July 10, 1984

Ref: Your letter of June 19 regarding Drainage Plan for McLean
Office/Warehouse Site

Based on your review, we have made several modifications and additions to the McLean drainage plan. These include the following as per your number comments in the June 19, 1984 letter.

DRAINAGE / GRADING PLAN
OFFICE & WAREHOUSE SITE
ZEARING AVENUE N.W.

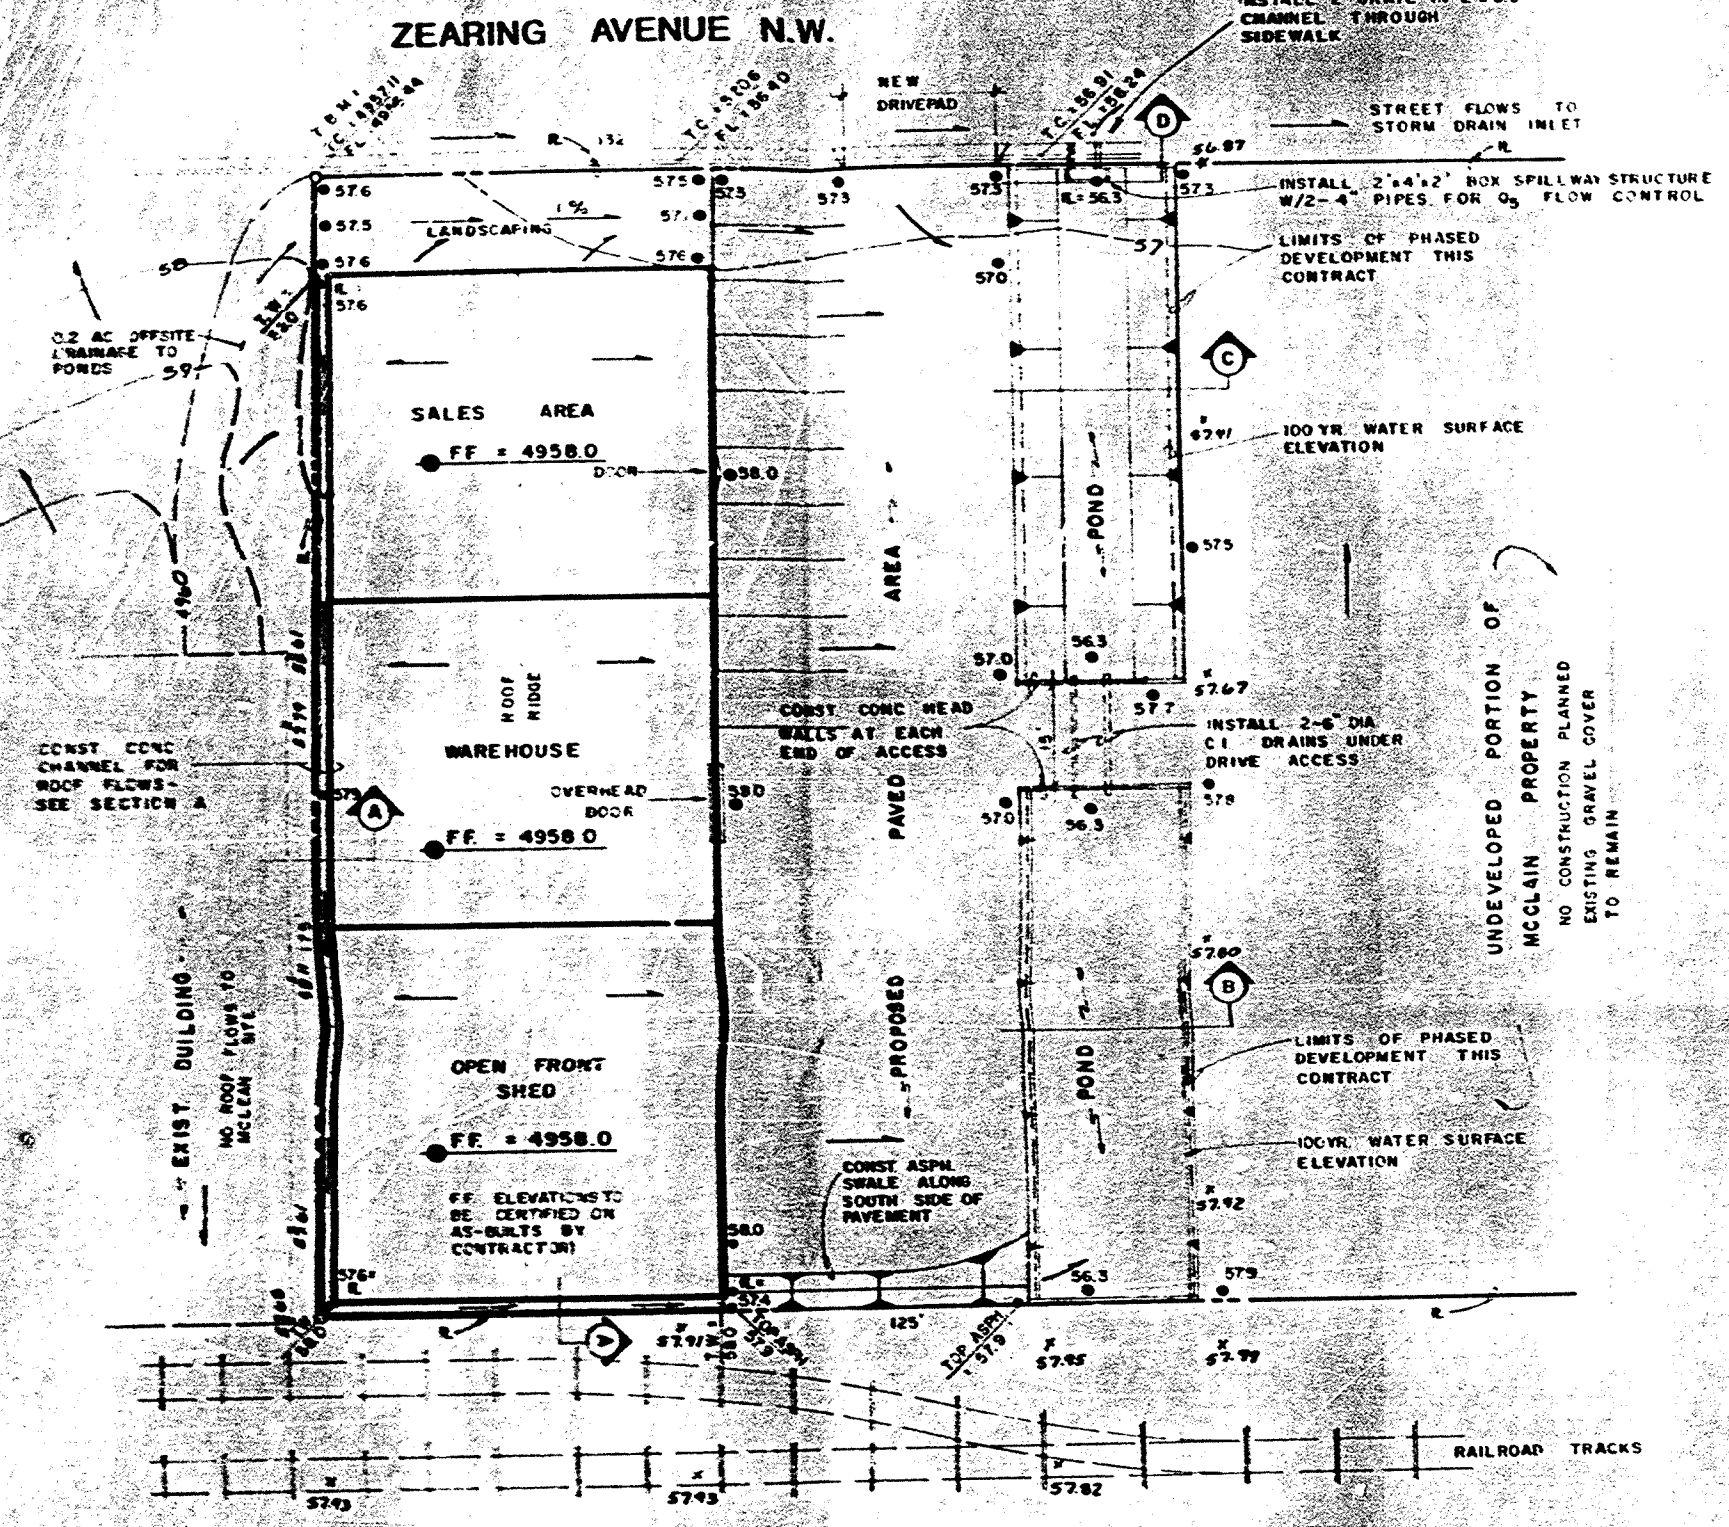
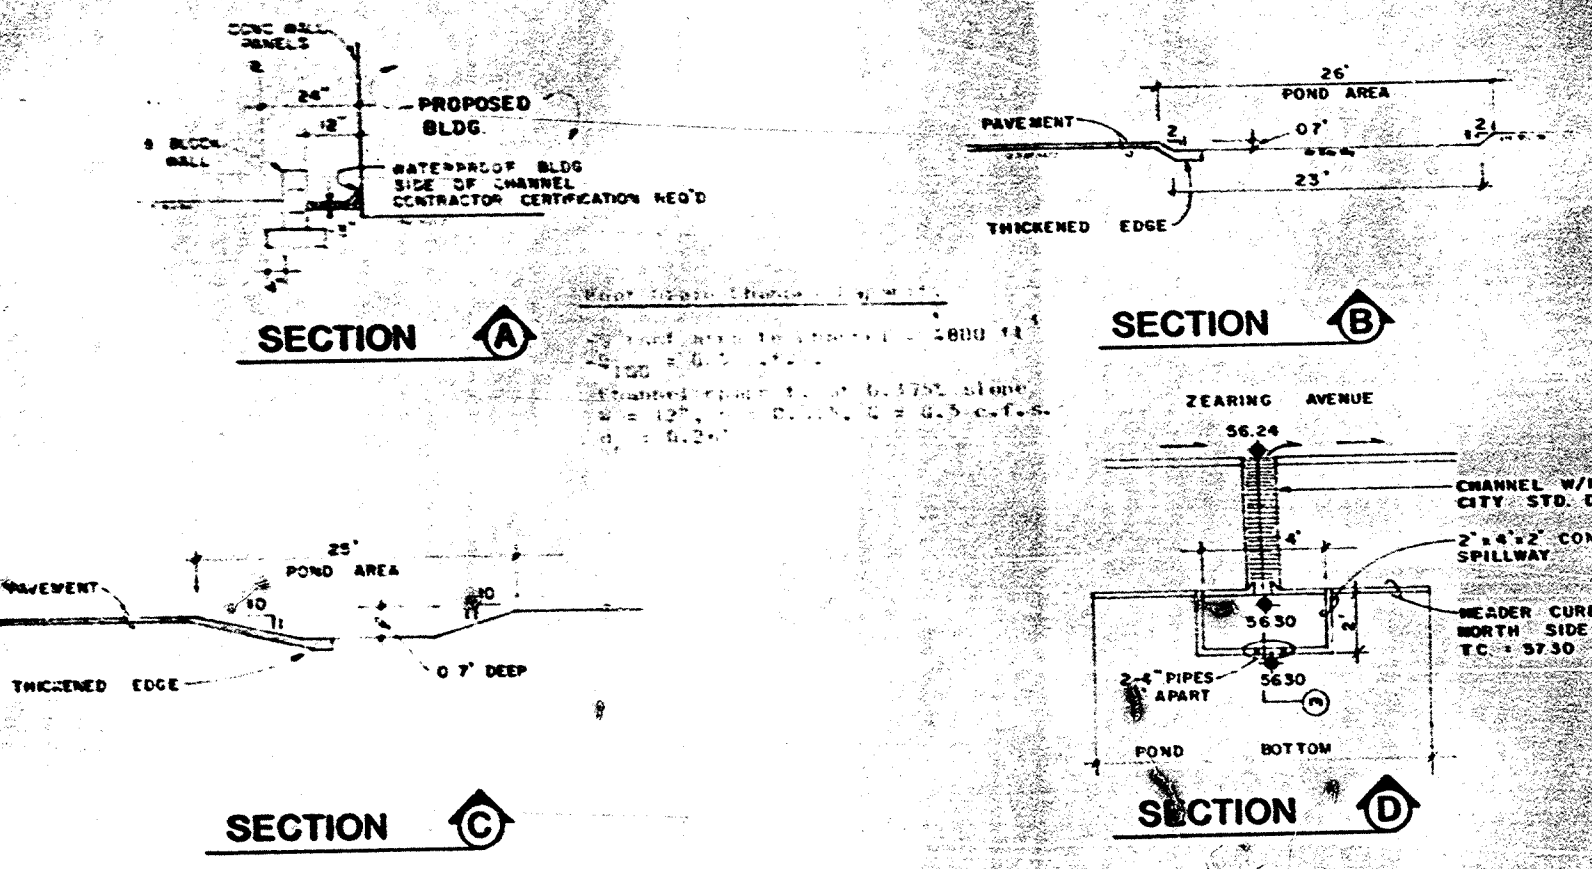
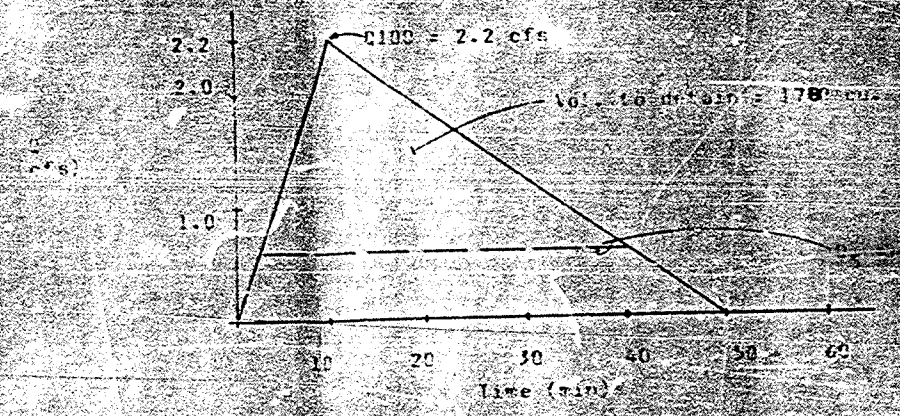
1. New information sheet is attached.
2. New signature and date is on drawing.
3. Pond calculation shown on Note 9c.
4. 100 year water surface is shown on plan.
5. Spillway has been redesigned as an 8' broad crested weir which discharges over a box configuration into a 2' wide covered sidewalk channel.
6. As shown on drawing (NW corner), offsite flows occur from a 0.02 acre unimproved area (insignificant volume). There are no roof flows to the McLean site from the adjacent building.
7. The undeveloped portion of the site will remain gravel covered and will not be disturbed by new construction.
8. Waterproofing certification requirement added to drawing.
9. Finish floor elevation certification requirement added to drawing.
10. "Drainage Facilities Within City R/W" document will be attached to construction drawings.
